**CWWTPR DCO Examination**

**Submission by Save Honey Hill Group****ISH4 – Draft DCO and Environmental Matters, 13 and 14 March 2024: Written Summary of Oral Submissions****2 April 2024****Introduction**

This note summarises oral submissions made by Ian Gilder for SHH at the ISH4 Hearing on 13 and 14 March 2024.

Table 4-1: Vehicle Routing for the proposed WWTP site access and offsite infrastructure

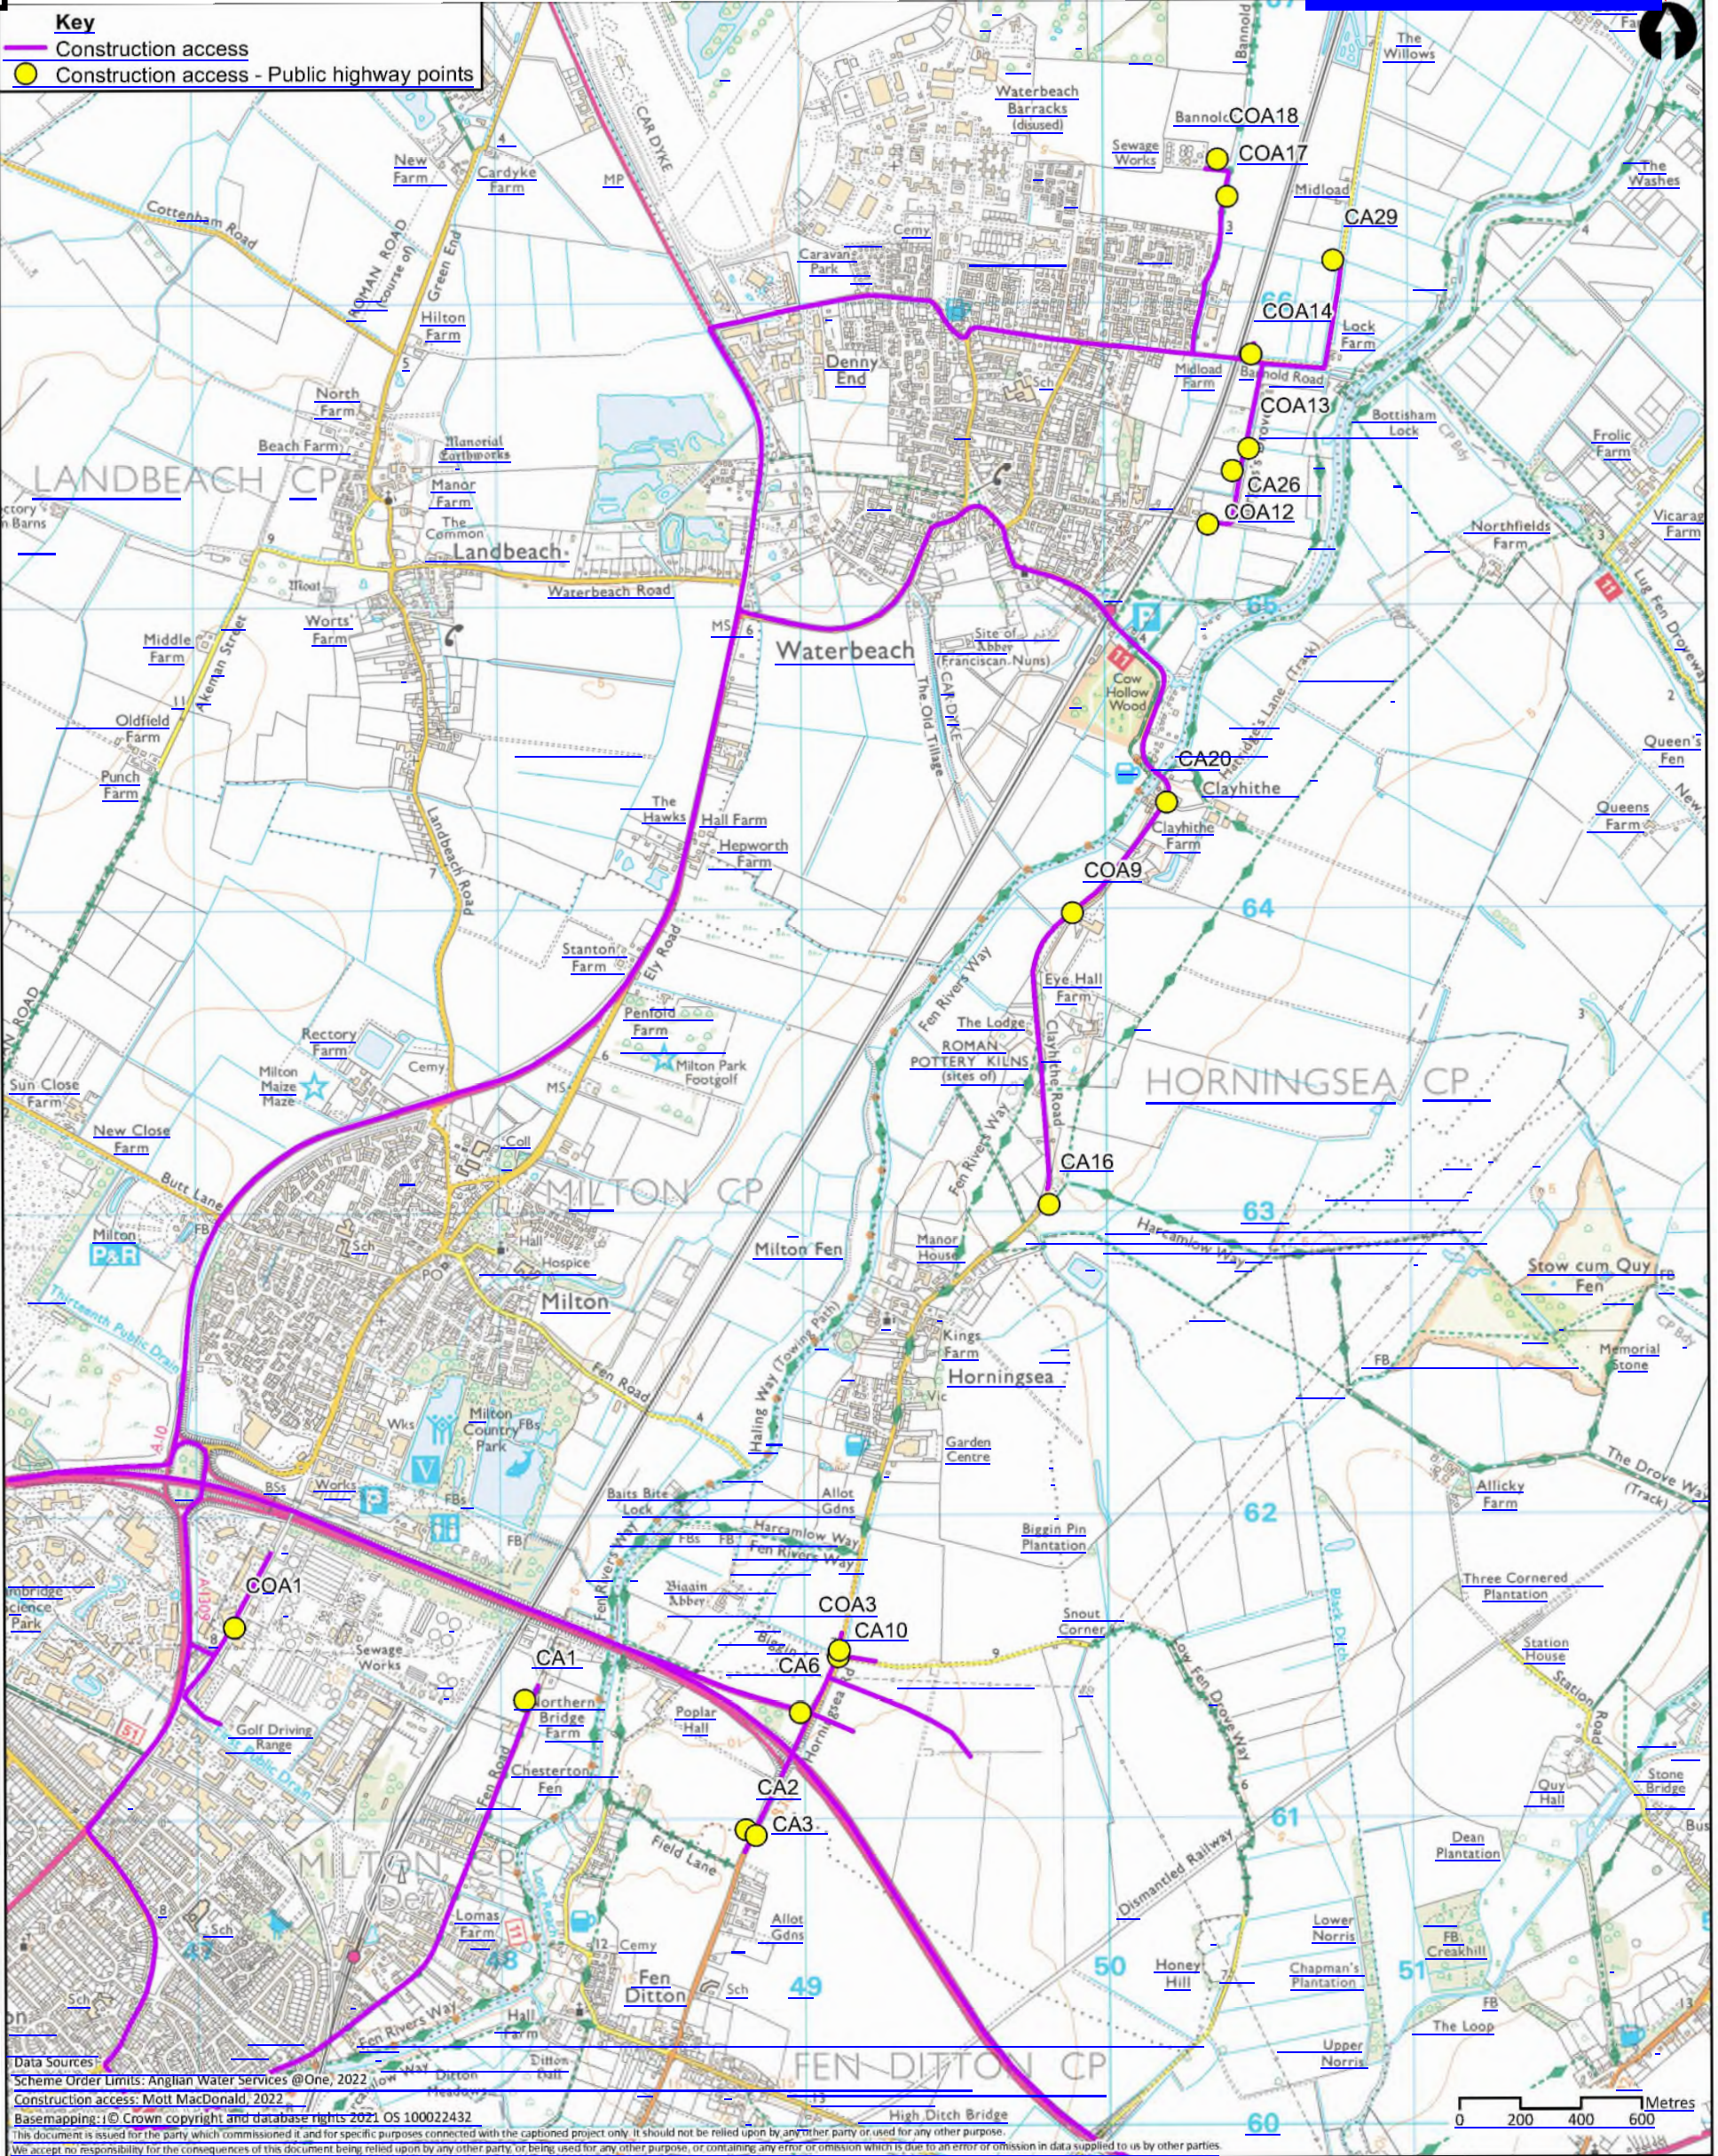
As requested by SHH58, Applicant has agreed to update this and other relevant figures to construction accesses and to show AIL routes, by virtue of weight over 44 tonnes ie through Waterbeach Station Road and other AIL routes, by virtue of size, separately.
